Application No: BE/59/21/PL
Site Address: 339 Chichester Road Bersted PO21 5AN
Description of works: Replacement of blockwork boundary wall with fence and new vehicular access (resubmission of BE/149/21/PL).

Thank you for your internet representation made on 7th June 2021 which has been recorded as an objection with the comments as follows:

SITE PLAN - SHOWING VISIBILITY SPLAYS
1:500 SCALE (at A3)

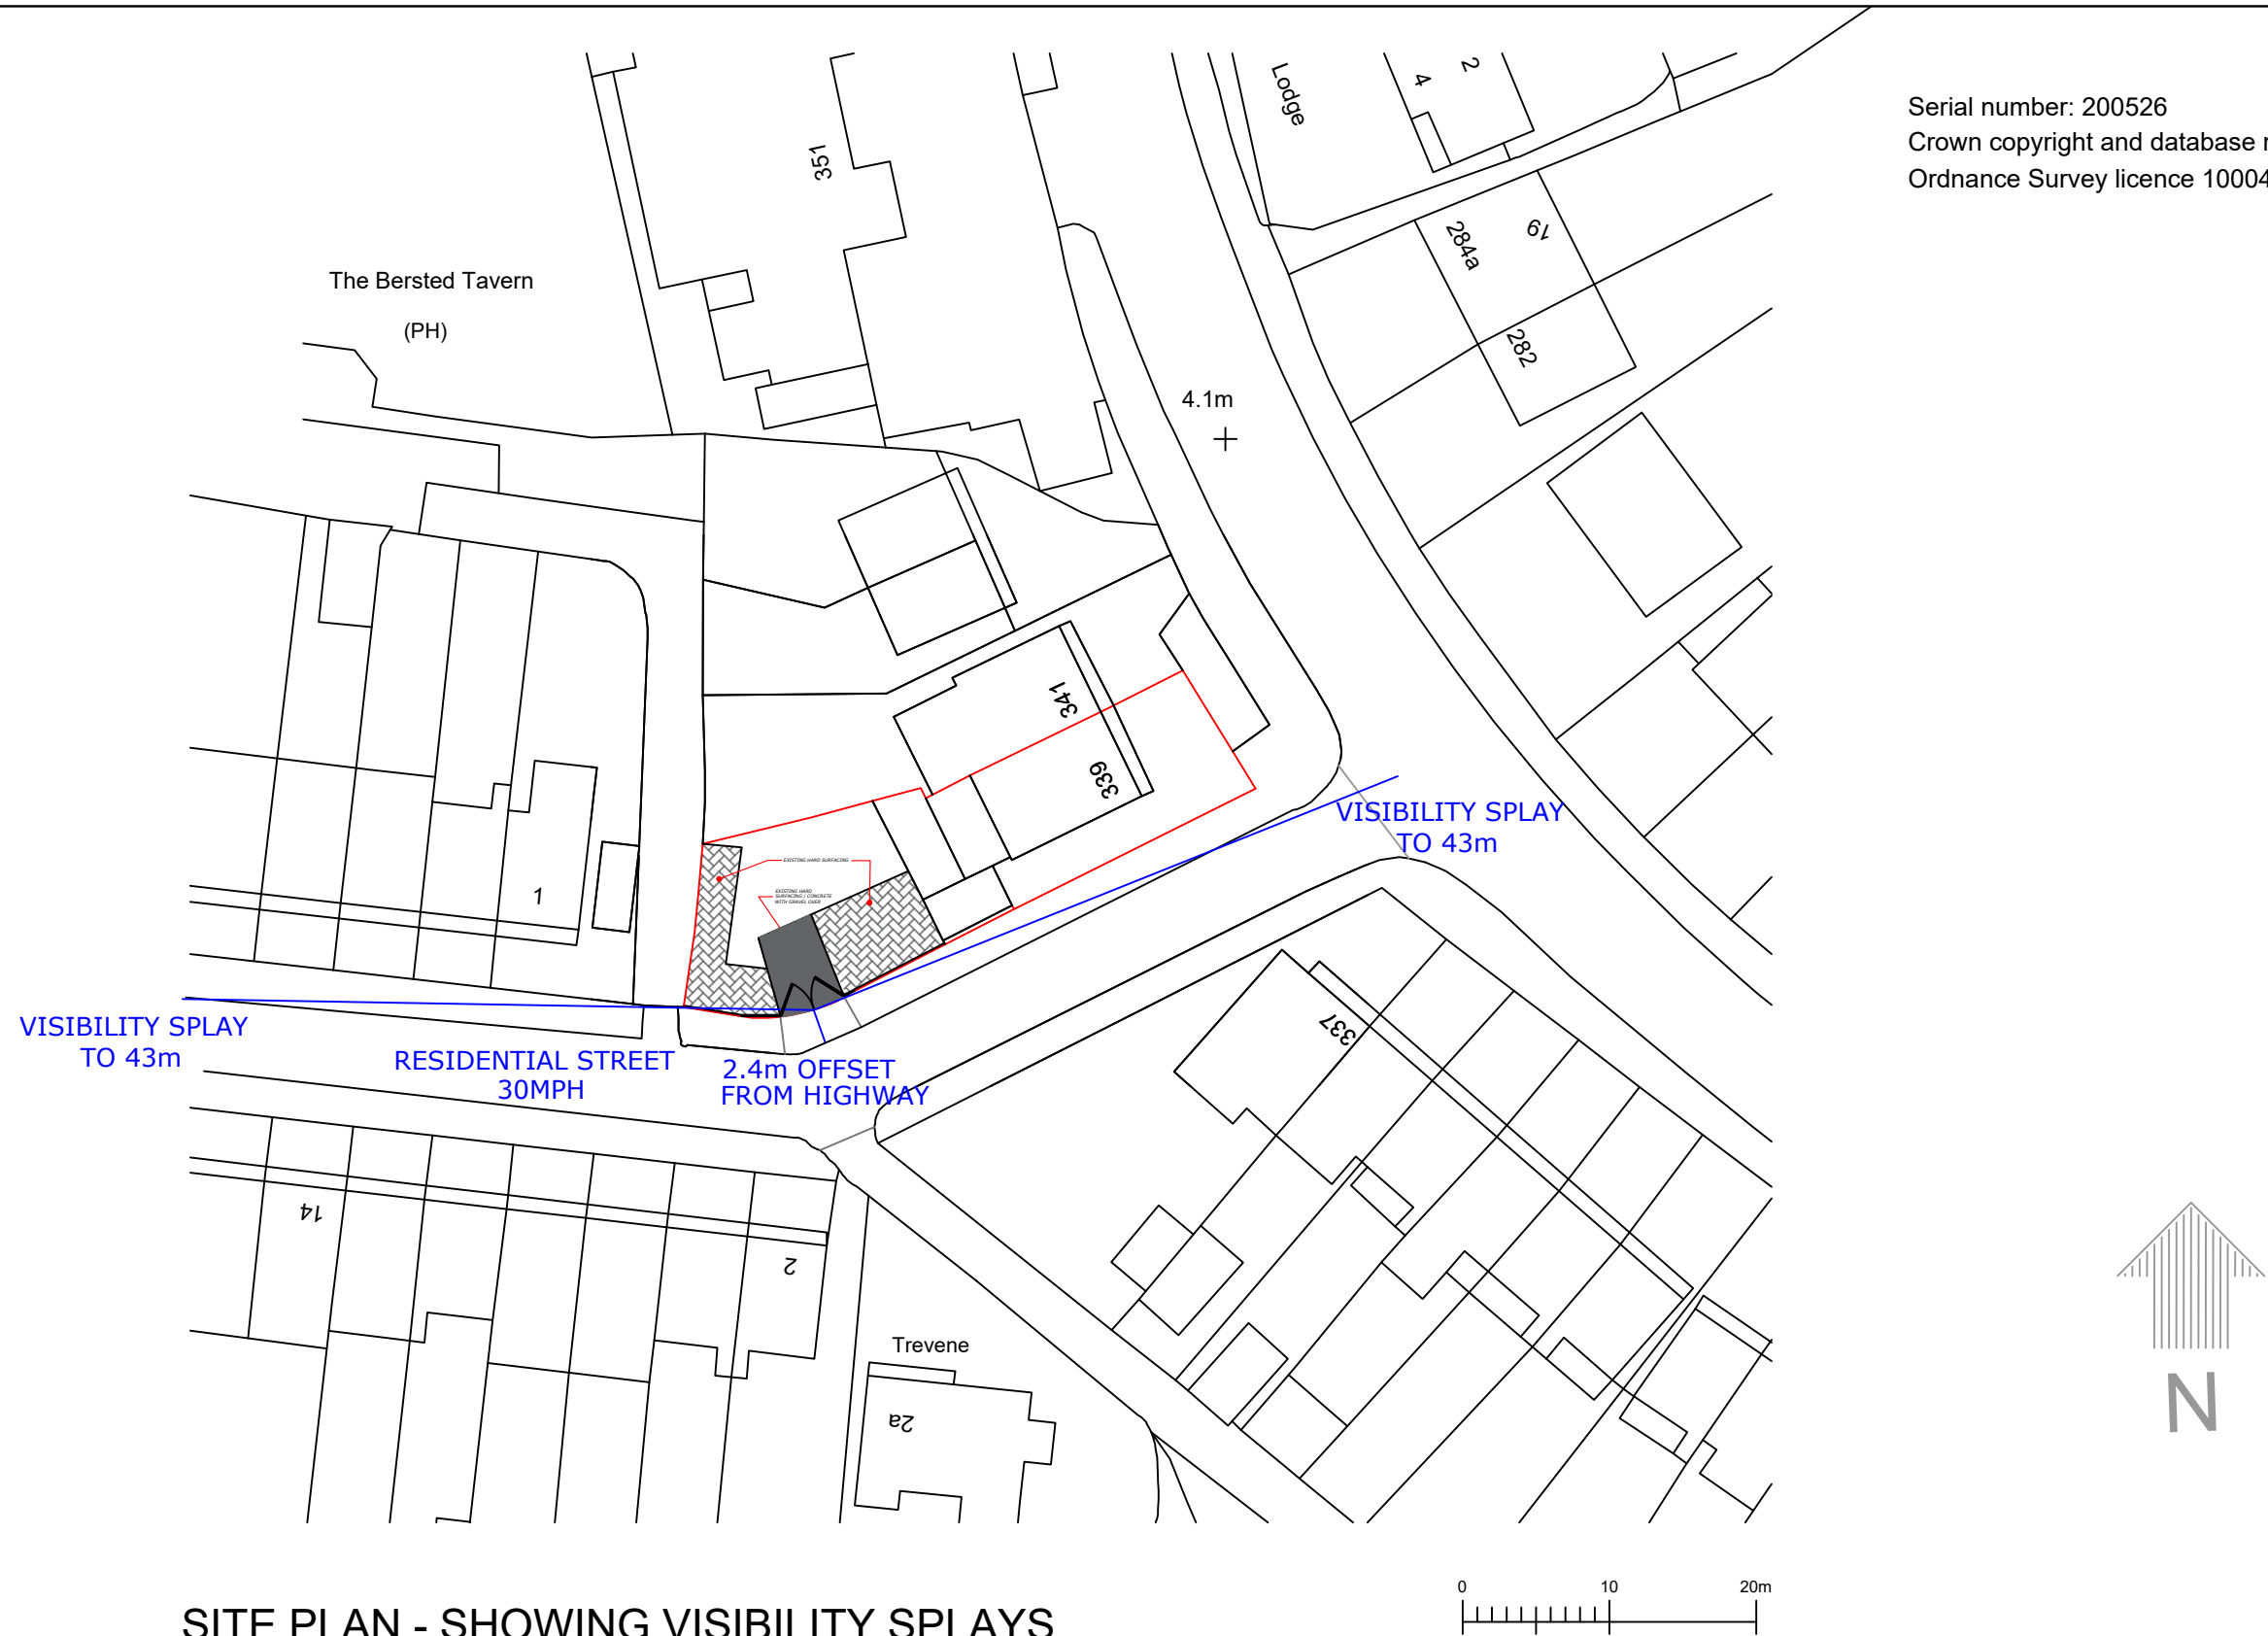
I strongly object to the application on safety grounds, traffic disruption, and parking access for emergency services.

My kitchen window looks directly onto the service road, the proposed kerb and the bend of the road.

Children are using the route for cycling, walking and engaging in outdoor activities between the service road and this dangerous bend in Bedford Avenue. Here, I have seen one accident and many near misses.

From 2006 West Sussex County Council installed bollards on the pavement bend of Bedford Avenue. There is limited visibility due to the rise in on-street parking. Since I requested double yellow lines, through traffic has increased from new developments and road layouts.
